Application for Removal or Variation of a Condition following Grant of Planning Permission or Listed Building Consent

Retrospective application for extensions to side and rear and first floor (an increase of 300mm to east elevation compared to previously approved applications 3/2021/0428 and 3/2021/1074) and the insertion of an additional window at ground floor on the eastern elevation. Obscure glass to sides of roof terrace and balcony as per existing approval. External stairs proposed to be re-positioned to rear (previously positioned on the East side).

Application 3/2023/0118

Condition 1 should relate to the updated drawings: 6219 P01J Proposed Elevations, 6219 P02J Proposed Floor Plans, 6219 P03I Proposed Site Plan. (All other referenced drawings to remain as current approval ref).

Drawing Title
Proposed Floor Plans

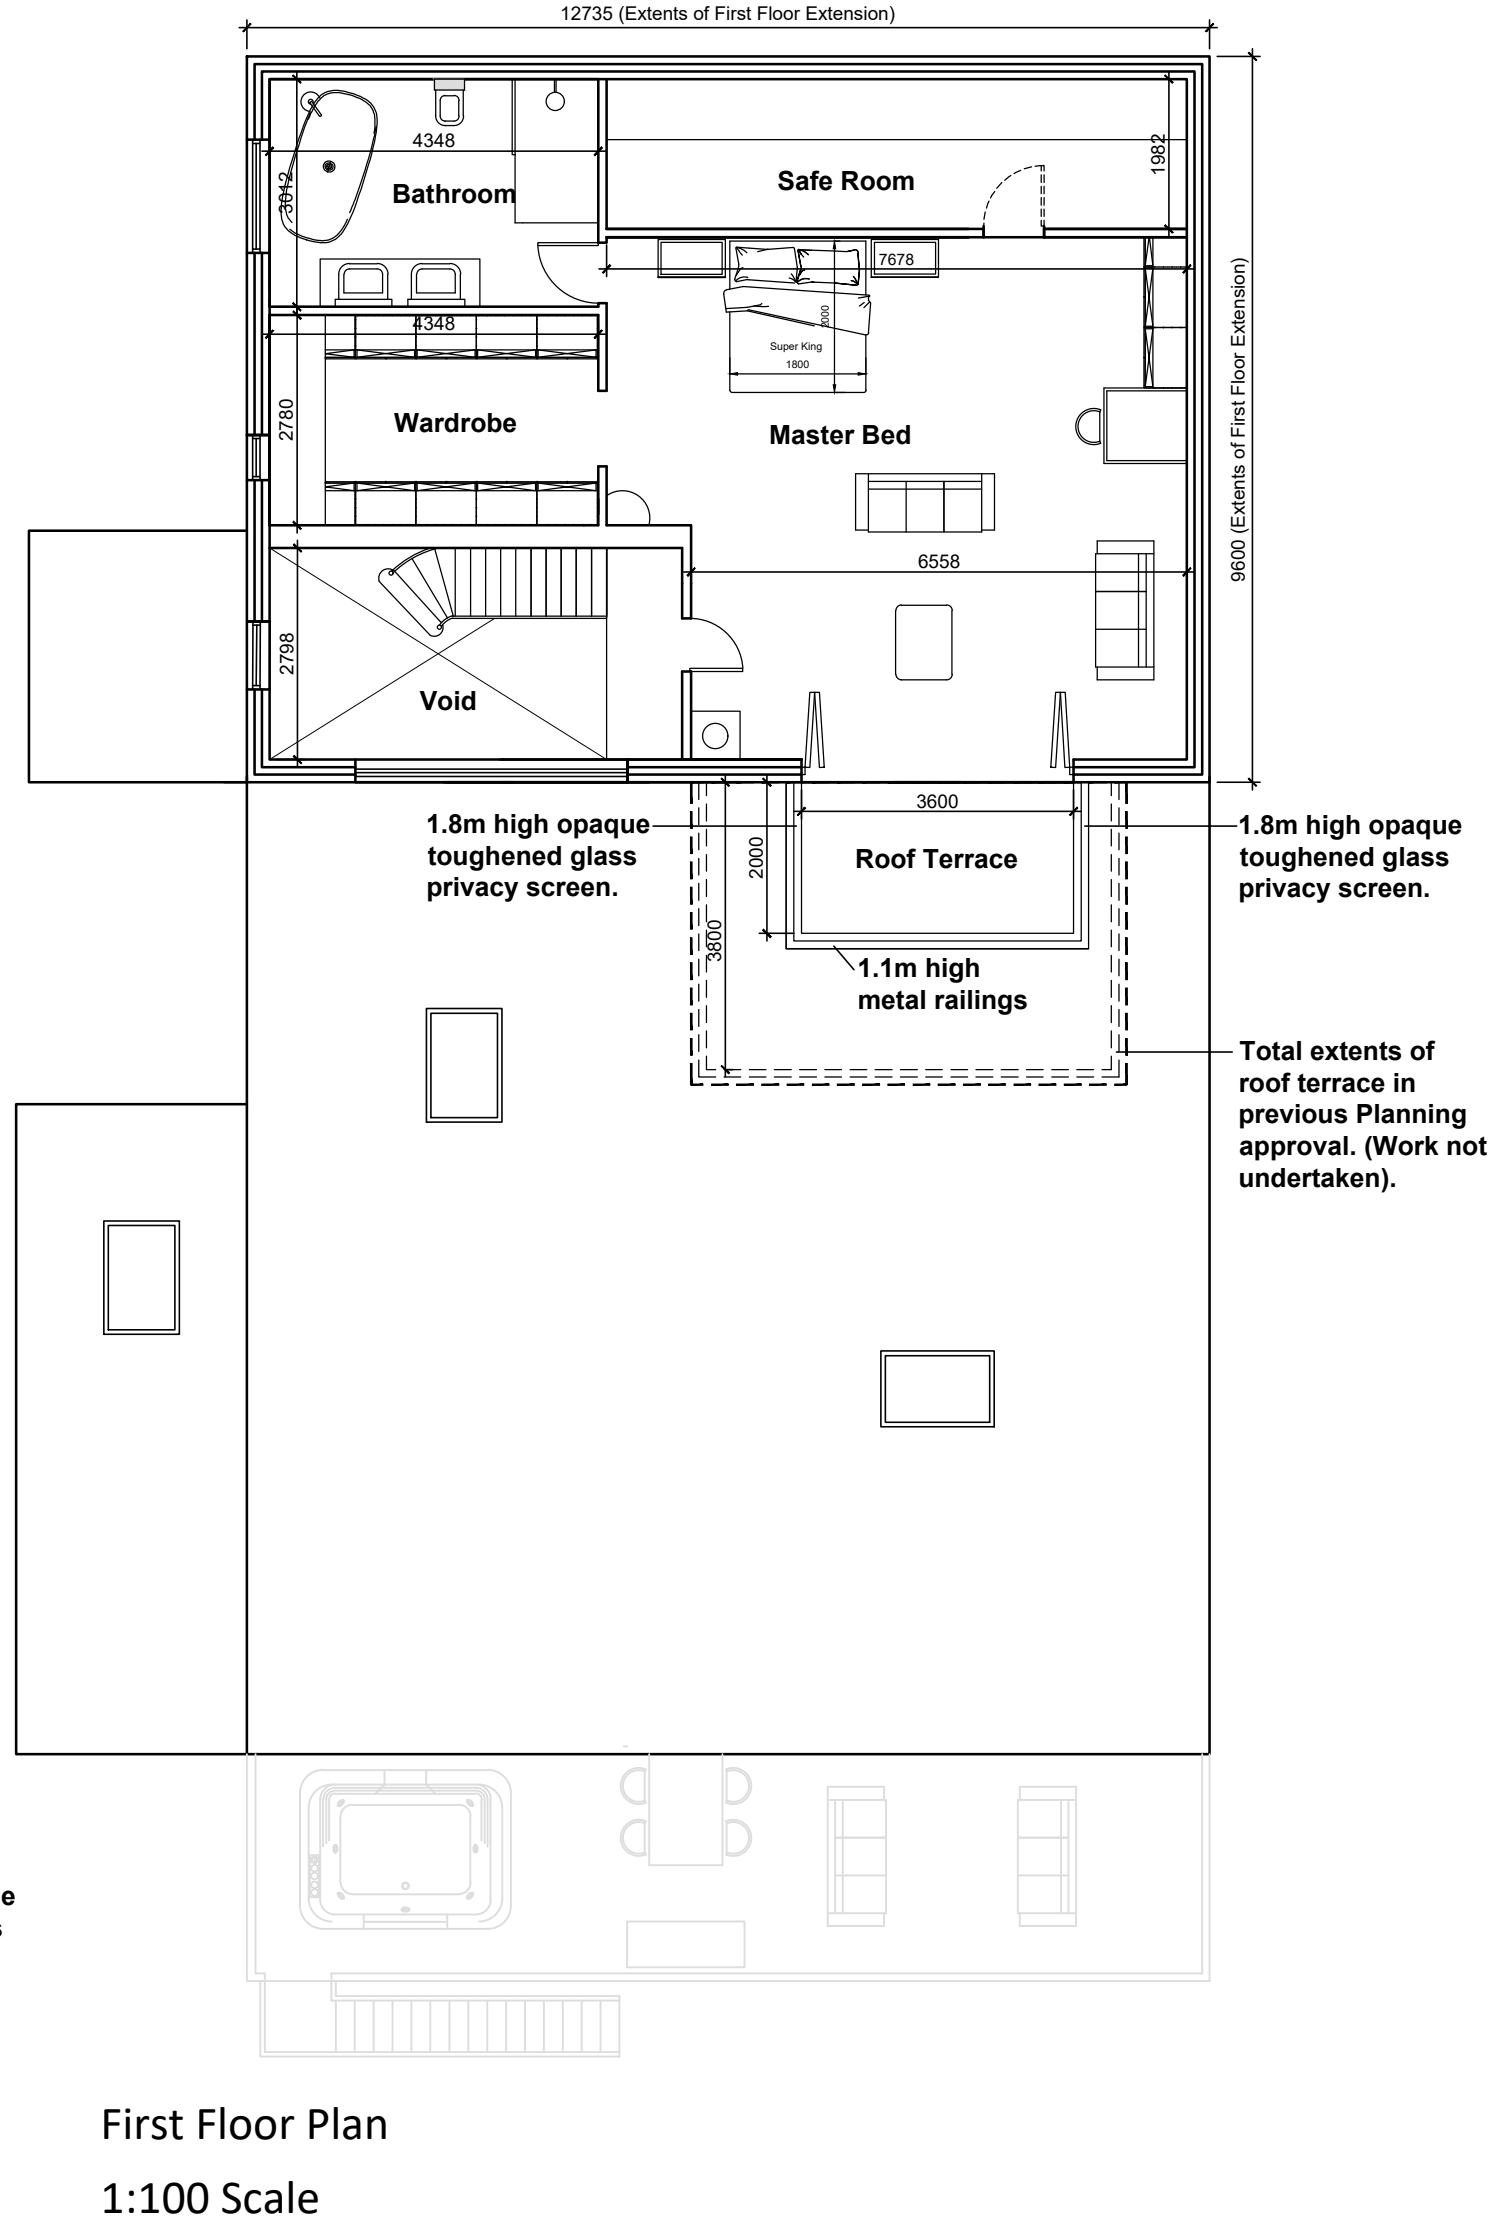
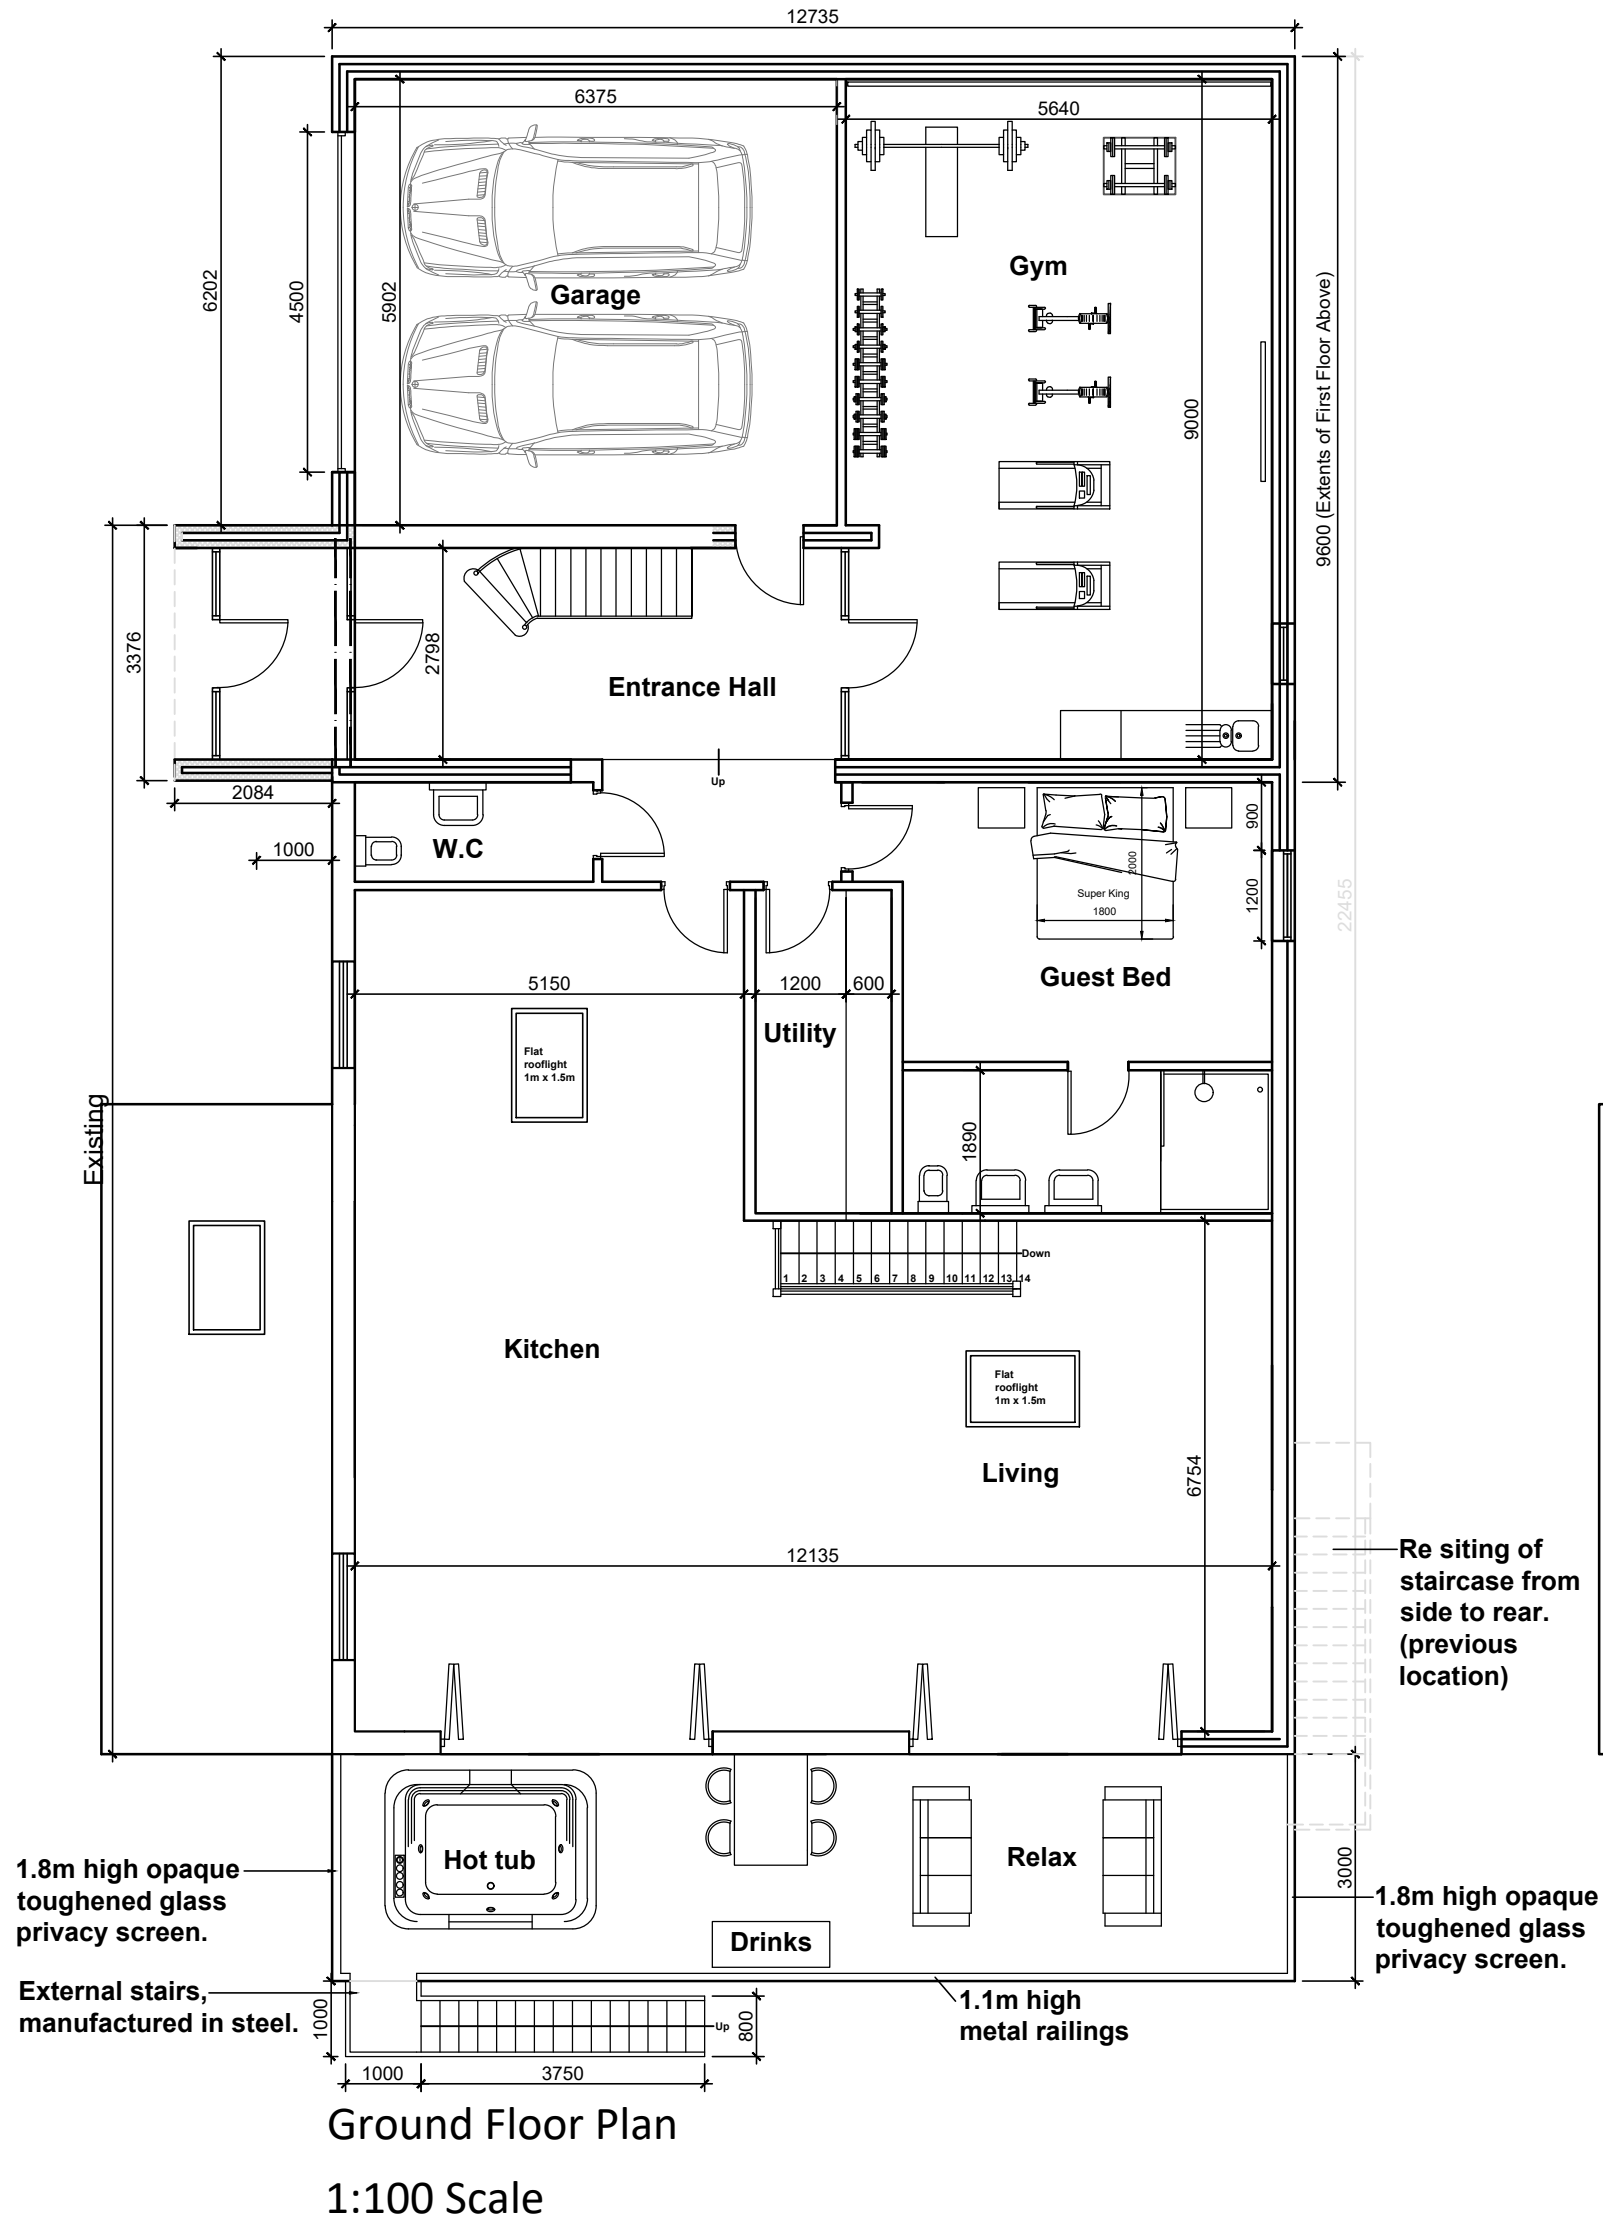
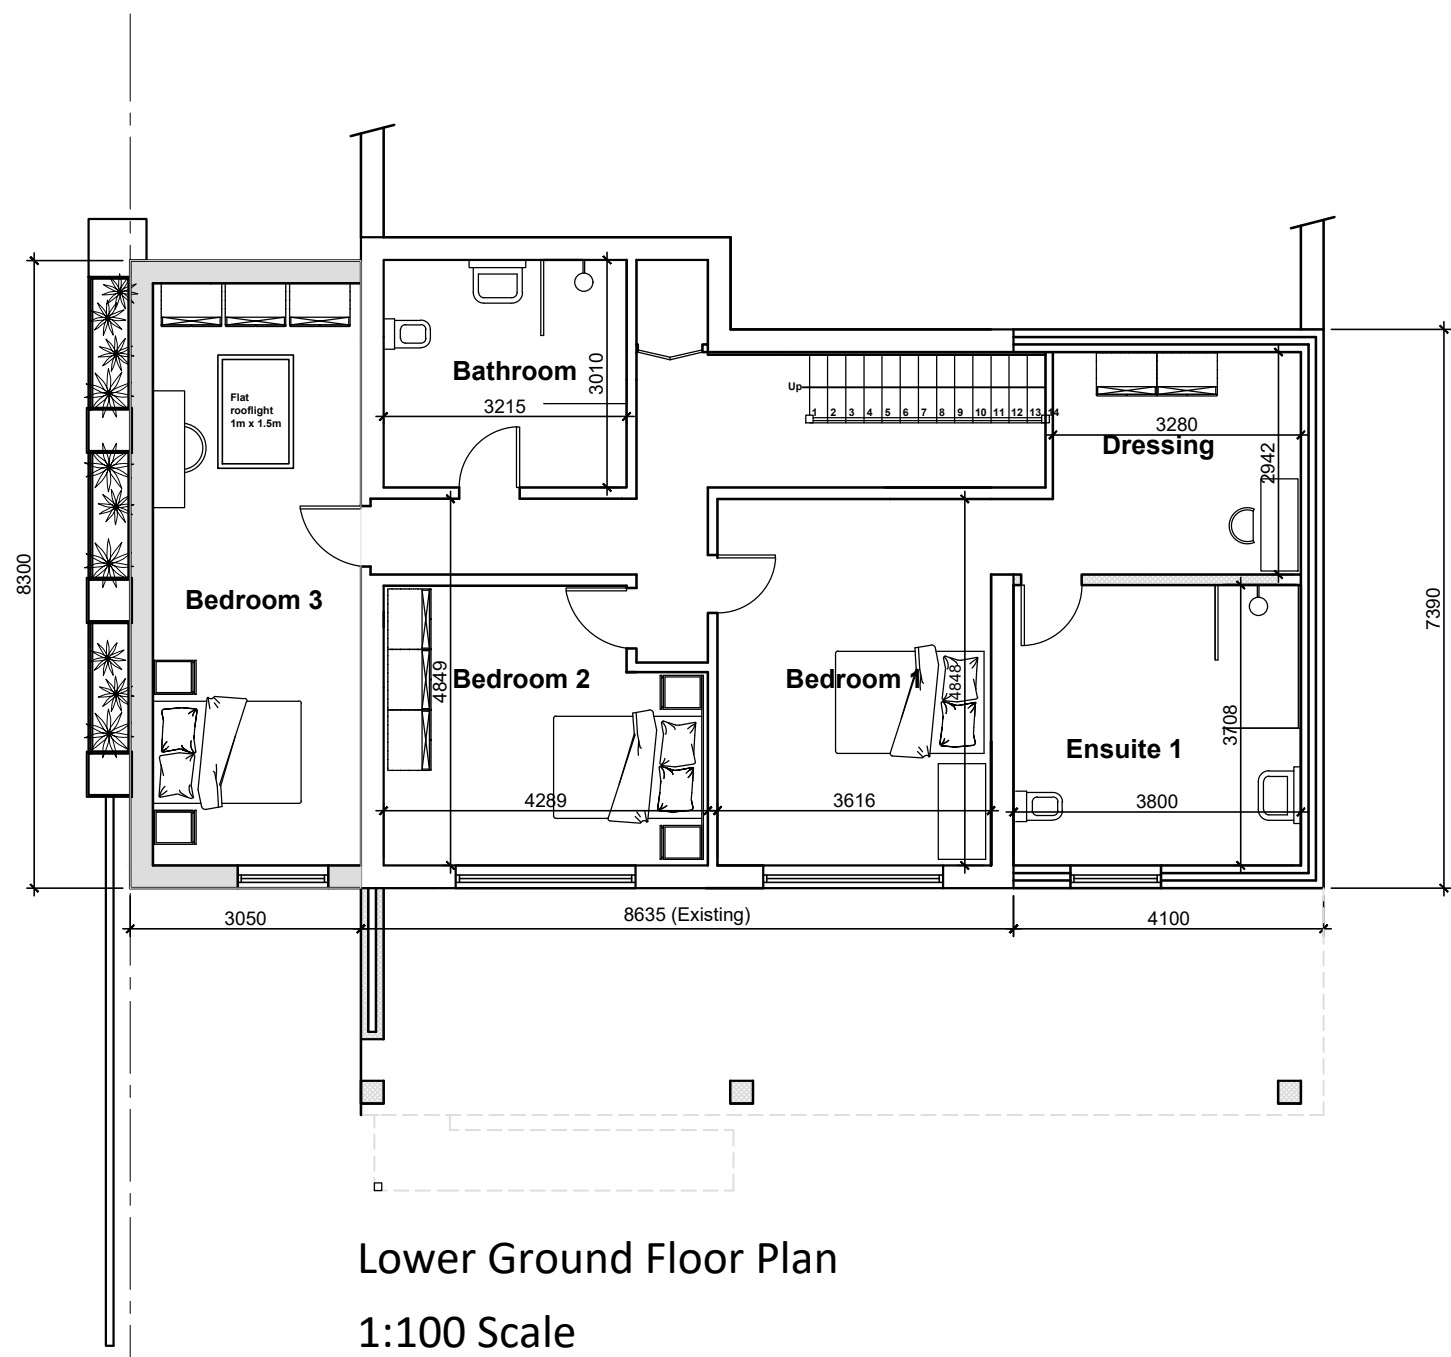
Drawing references to be updated to as built / in progress drawings following review on site. Privacy glazing reinstated with 1.1m metal railings towards rear garden. Minor amendments to window sizes and openers. External staircase repositioned on the rear (previously on the East side). All updated on Proposed Floor Plan and Proposed Elevation drawings.
